## 31 Fore ST

**David Margolis-Pineo** <DMP@portlandmaine.gov> Wed, Mar 2, 2016 at 4:30 PM  
To: "Barhydt, Barbara" <BAB@portlandmaine.gov>, "Fraser, Jean" <JF@portlandmaine.gov>, "Barhydt, Barbara" <bab@gapps.portlandmaine.gov>  
Cc: "Errico, Tom" <thomas.errico@tylin.com>

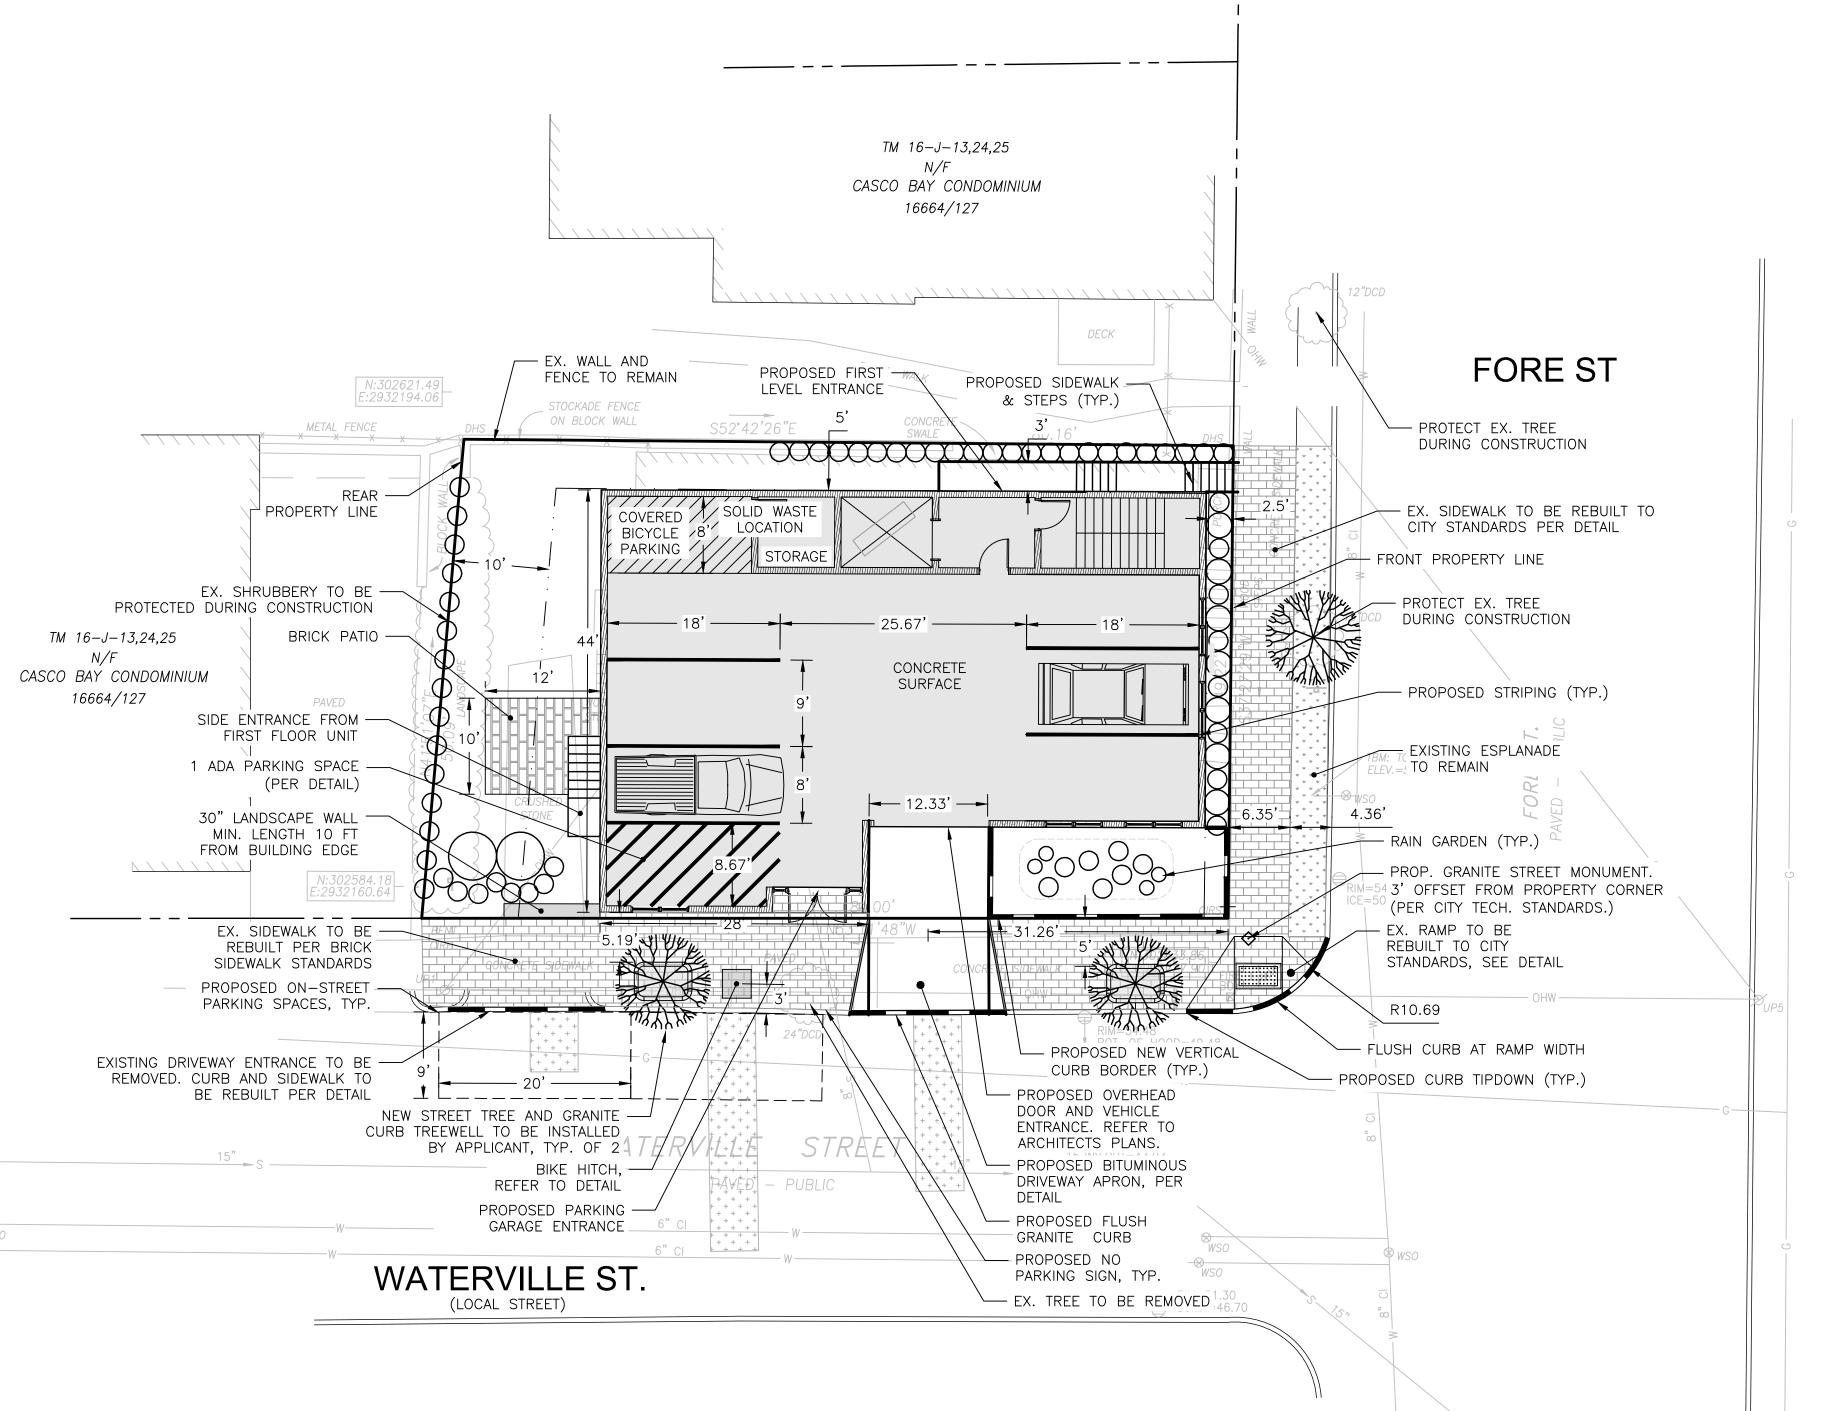
I have review the newly submitted plan. The center of drive is now located 32' from the corner verus the required 35'. This department is supportive of allowing a waiver for three feet.
